Subject: Written Representation Submission for
Deadline 1 – East Pye Solar (EN0110014)

- Project Name: East Pye Solar
- Project Reference: EN0110014
- Submission Content: Full Written
Representation containing an integrated
Executive Summary, Methodological
Disclosure, primary evidence exhibits, and
specific cross-examination questions
regarding parameter contradictions, battery
storage queue status limitations, and

SECTION 1: SITE ONE (THE CENTRAL TRANSMISSION & BESS COMPLEX)

- Sites
- Proposed BESS
- National Grid Substation Site and Point of Connection
- National Grid Substation Option 2 Site and Point of Connection
- Cable Route Corridor
- 1A Site/Sub Site Number
- CRC1 Cable Route Corridor Number

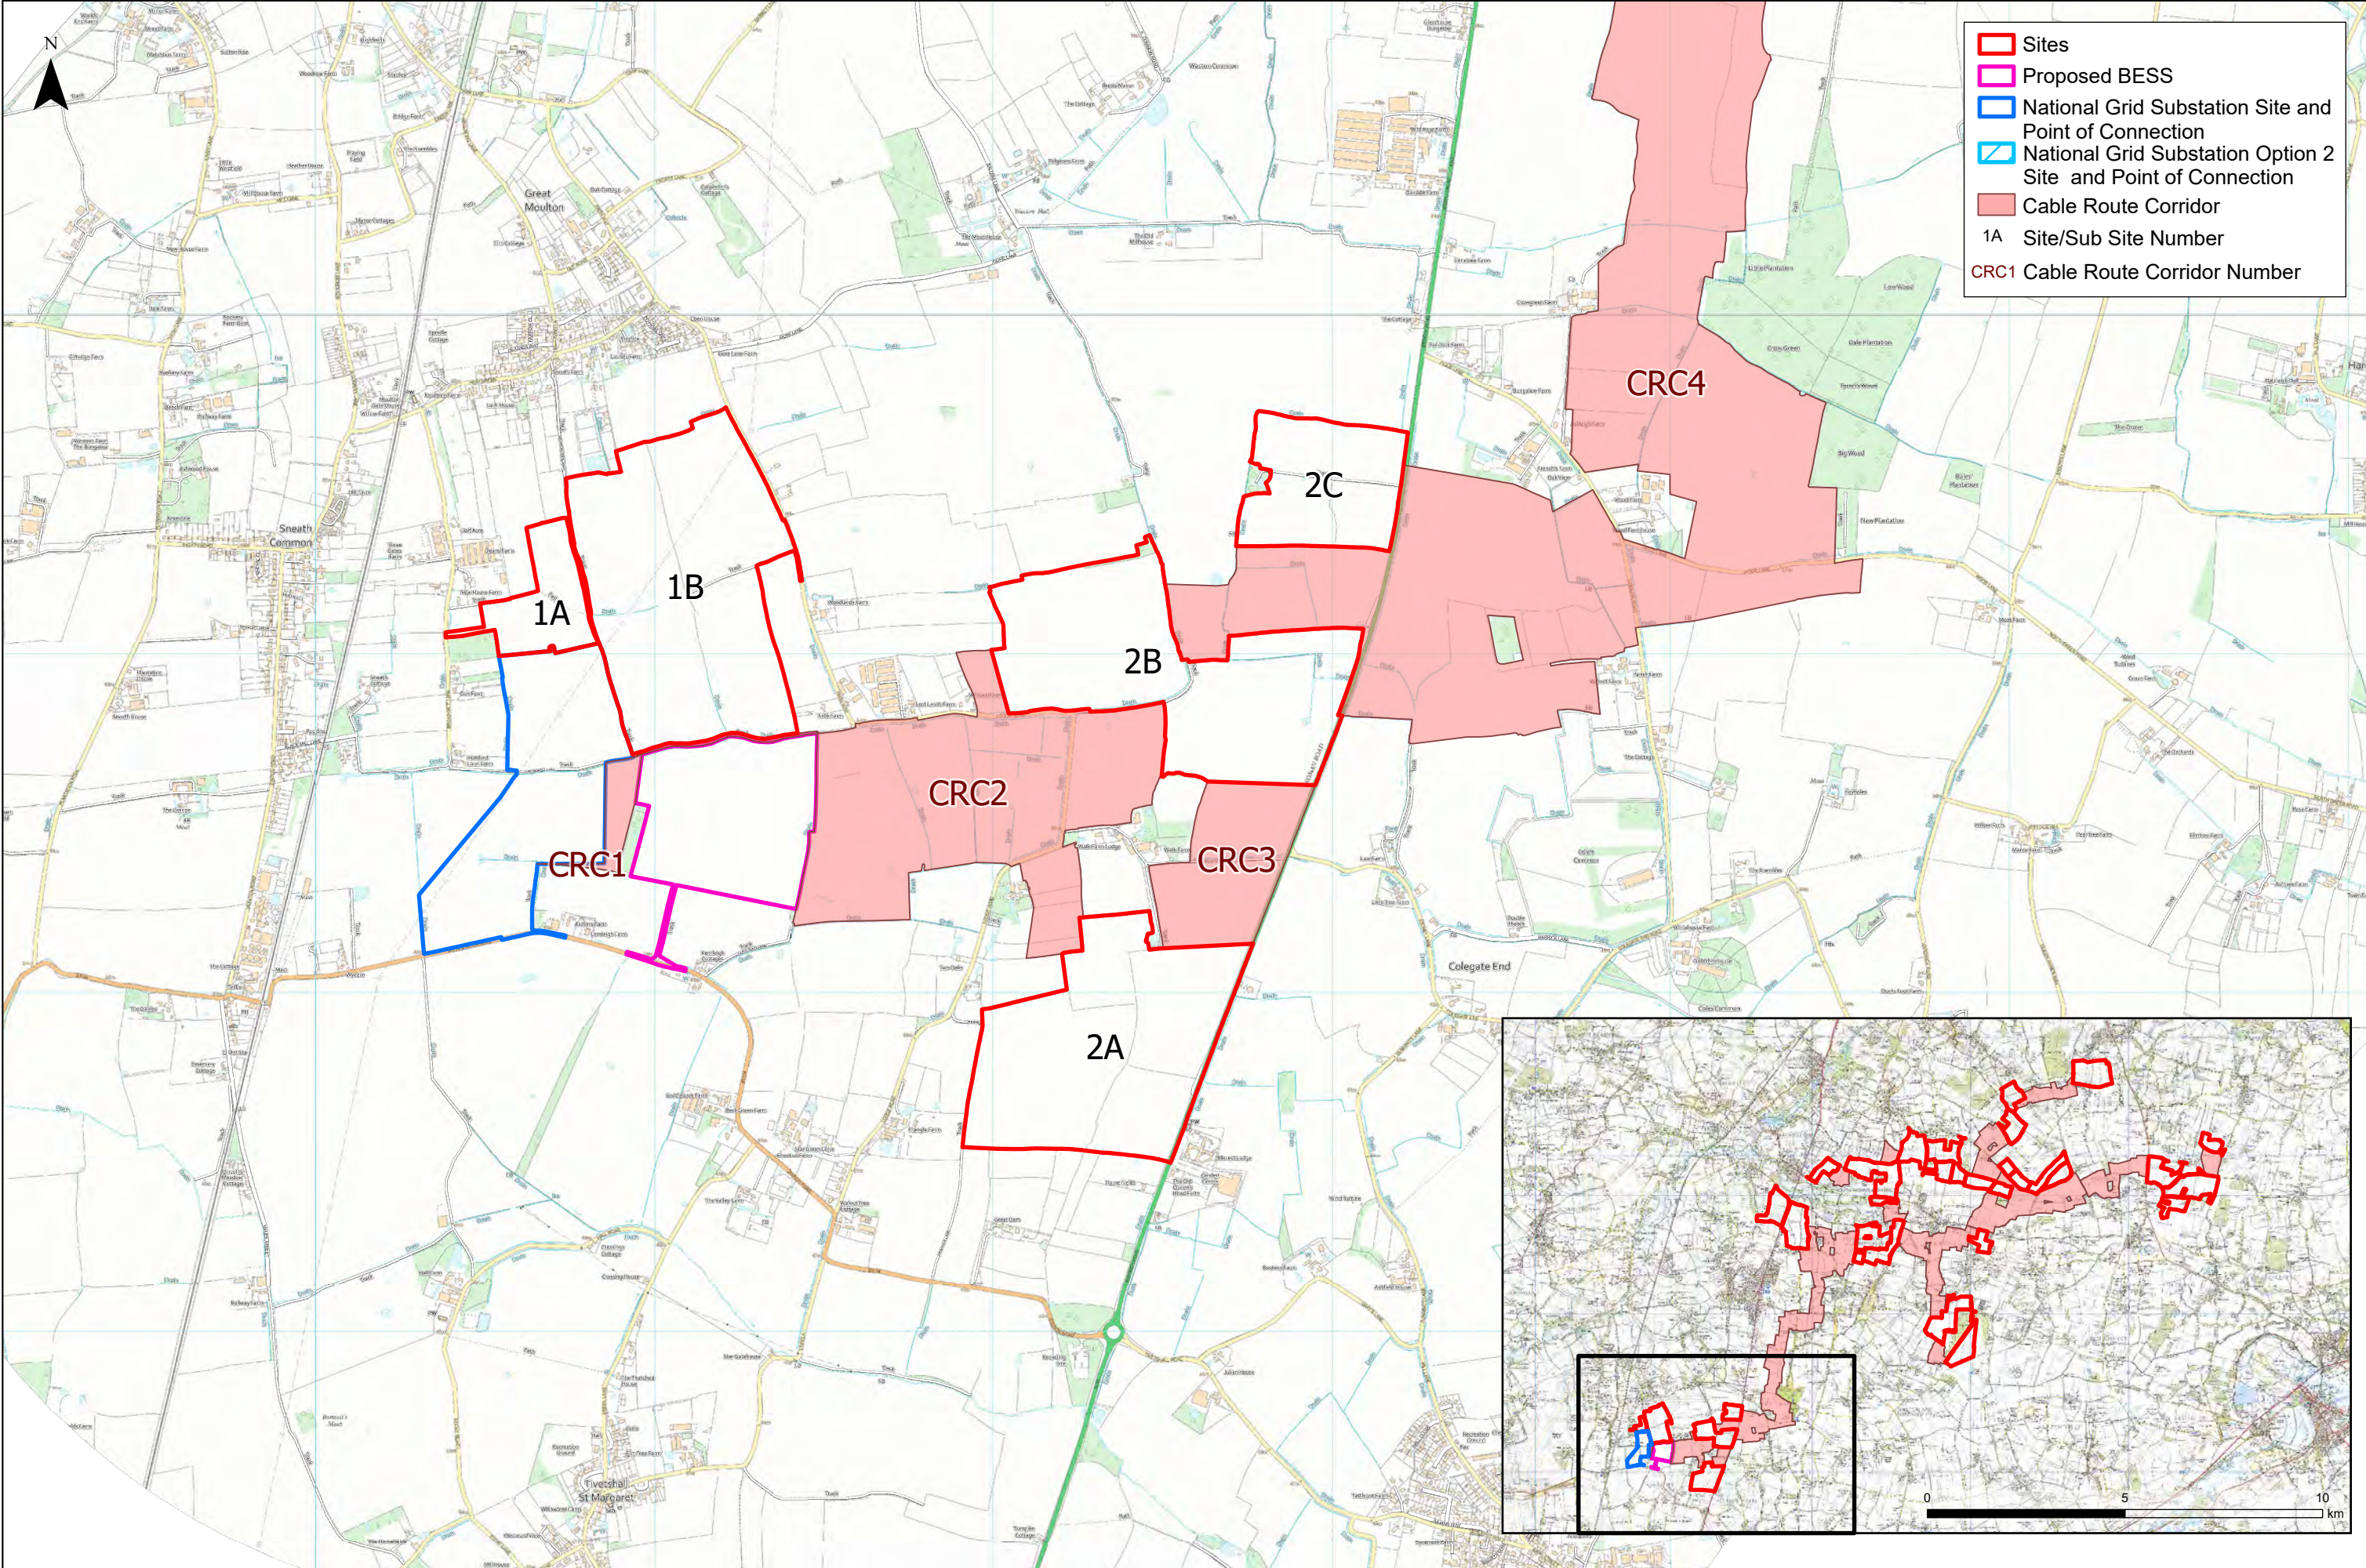
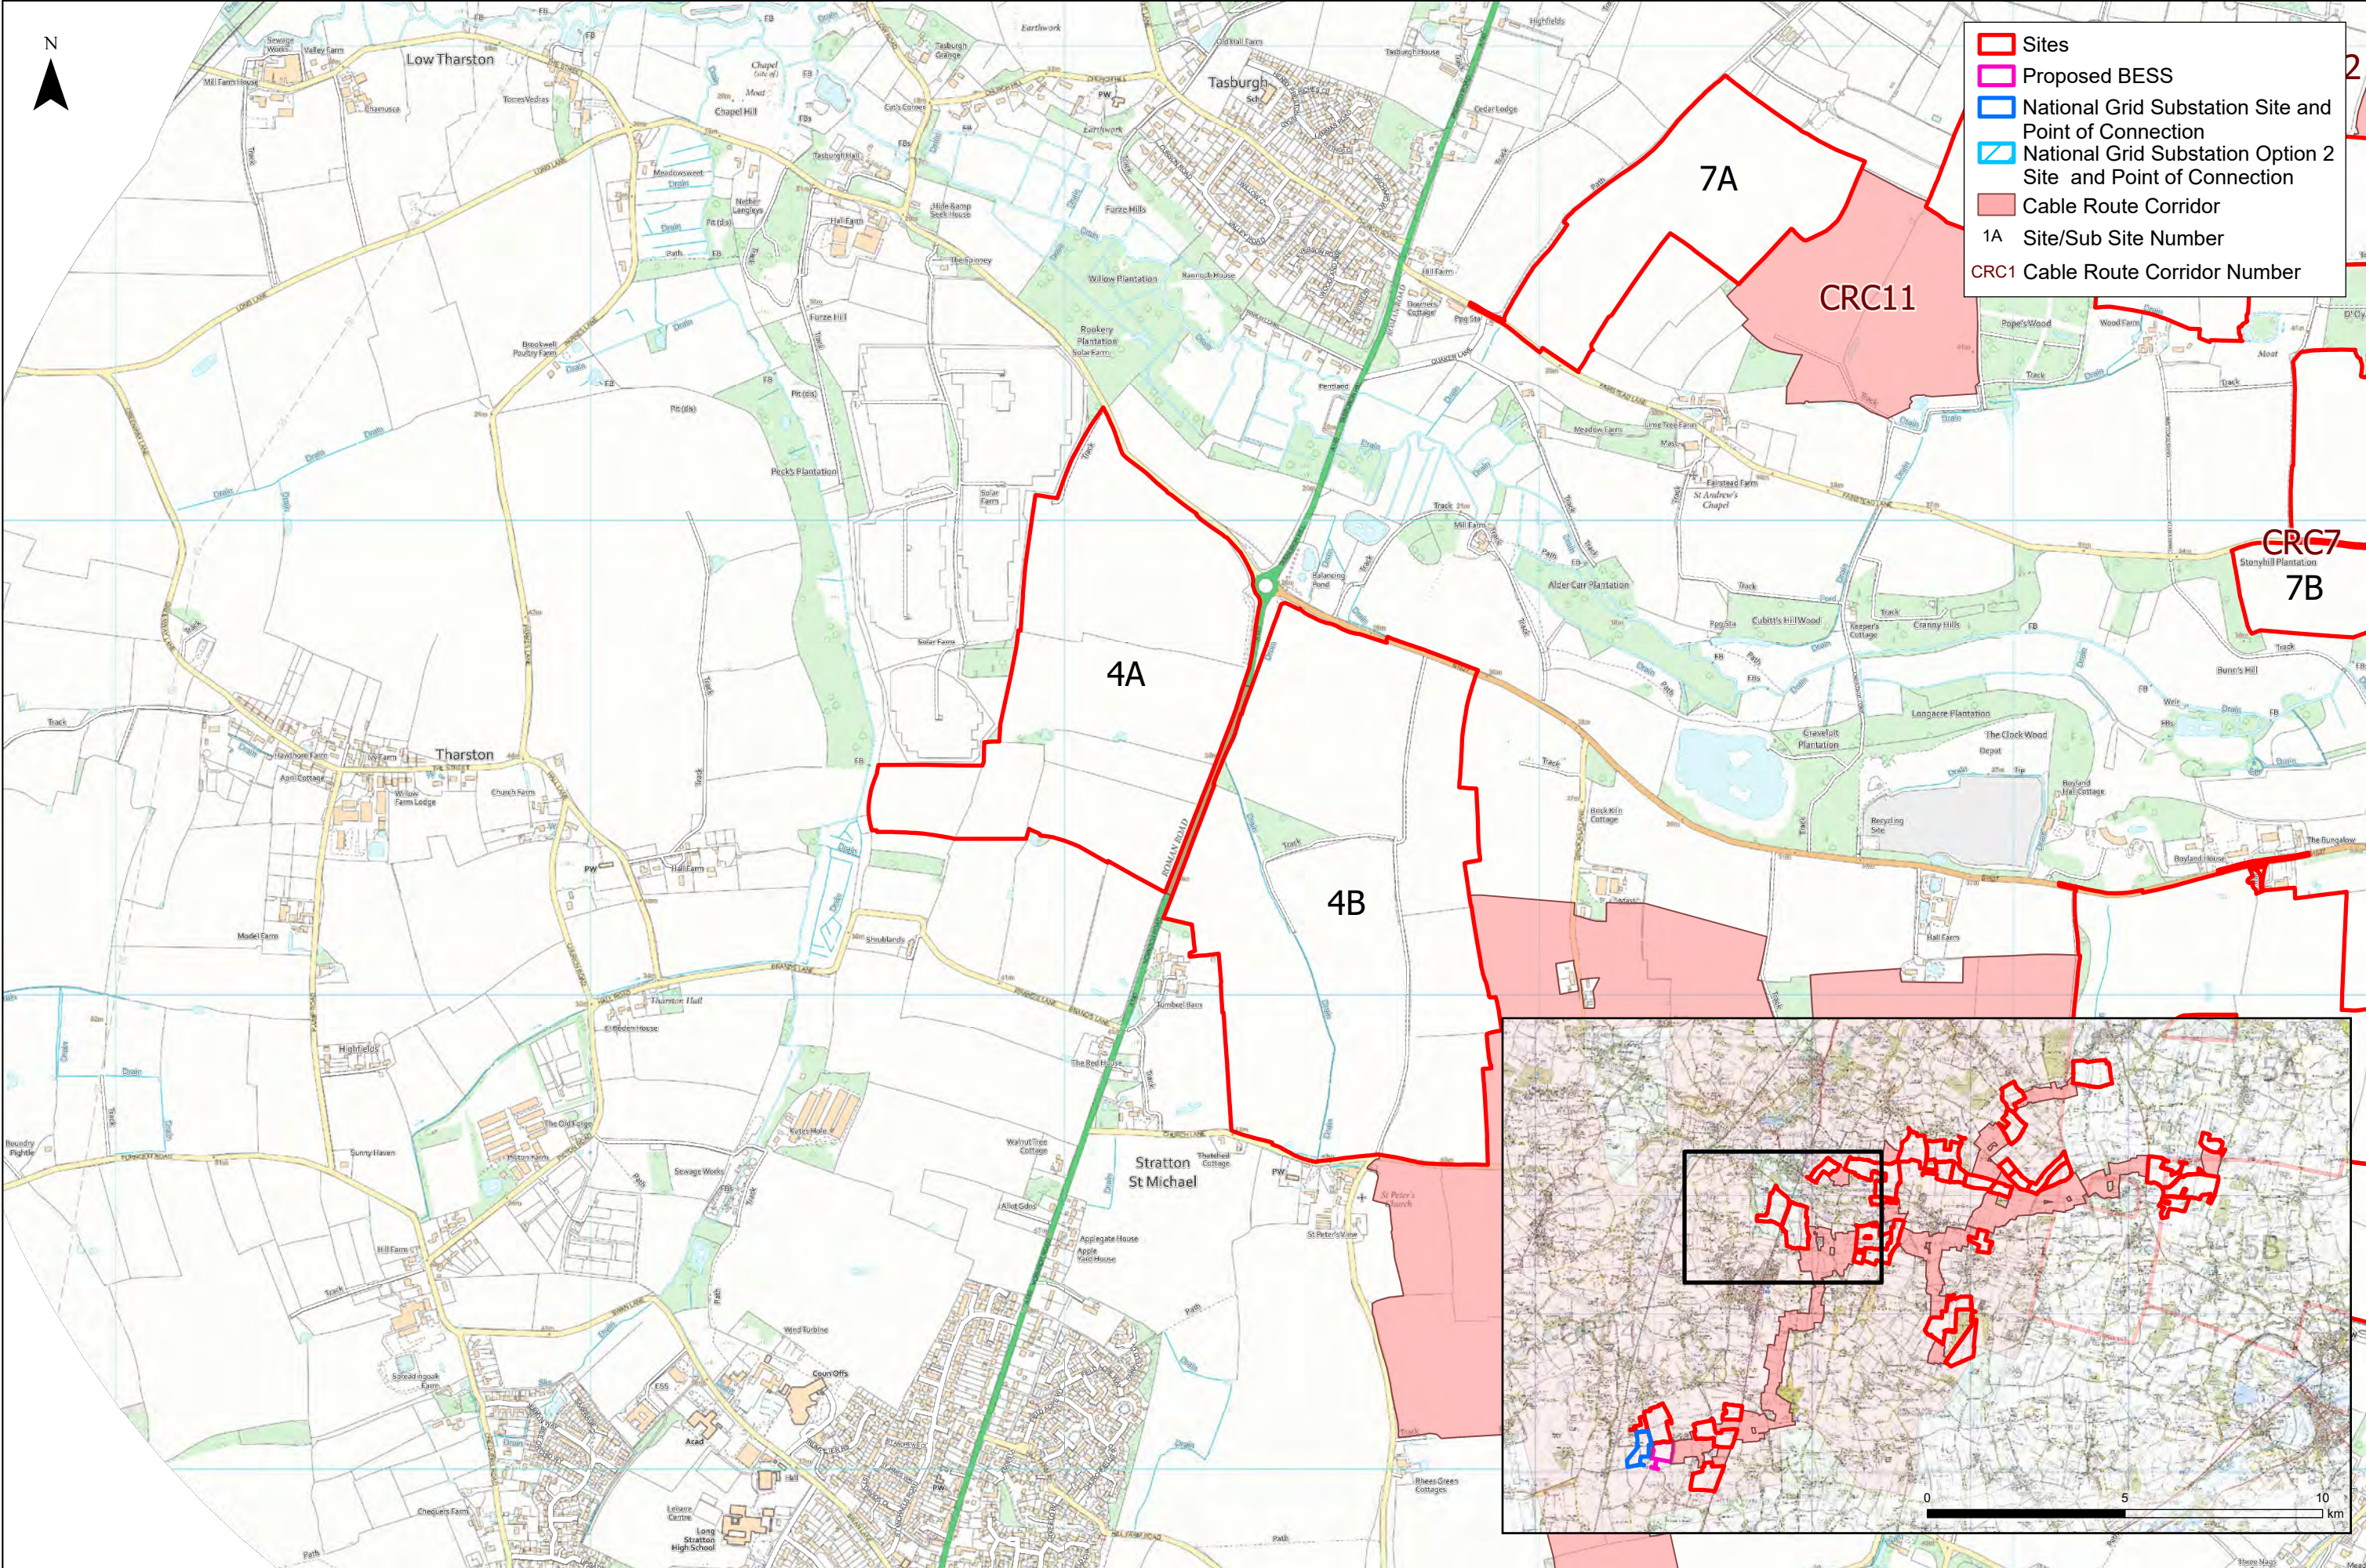
A major contradiction exists between the submitted graphic plans, the public consultation promises, and the accompanying written text. The Applicant's framework explicitly stated that the development would be limited to a maximum parameters of three 132 kV substations and three 400 kV substations

across the entire project. However, the site plans demarcate three distinct 400 kV voltage class substations within the concentrated Site One compound alone, while a fourth 400 kV substation footprint is explicitly drawn on the master maps at Site 7 near Saxlingham Green. Component heights track up to a maximum parameter of 15 metres. Furthermore, specific hardware models remain uncommitted until post-consent procurement, meaning equipment options produce divergent acoustic signatures near residential boundaries. The Applicant's environmental noise statement relies on generalized acoustic models tailored exclusively to a neurotypical baseline, omitting any technical assessment for the neurodivergent baseline of the host community. For individuals with neurodivergent profiles or sensory processing differences, un-filterable low-frequency industrial noise represents an

- Question to the Applicant 3: "The Applicant's consultation literature explicitly stated that the development parameters would be structurally capped at a maximum of three 400 kV substations. Given that the submitted master layout maps clearly demarcate three 400 kV substations within the concentrated Site One compound alone, and a fourth 400 kV substation footprint drawn at Site 7 near Saxlingham Green, will

own maximum promised infrastructure caps on the plans, and clarify exactly how many individual 400 kV substations are to be constructed under this DCO?"
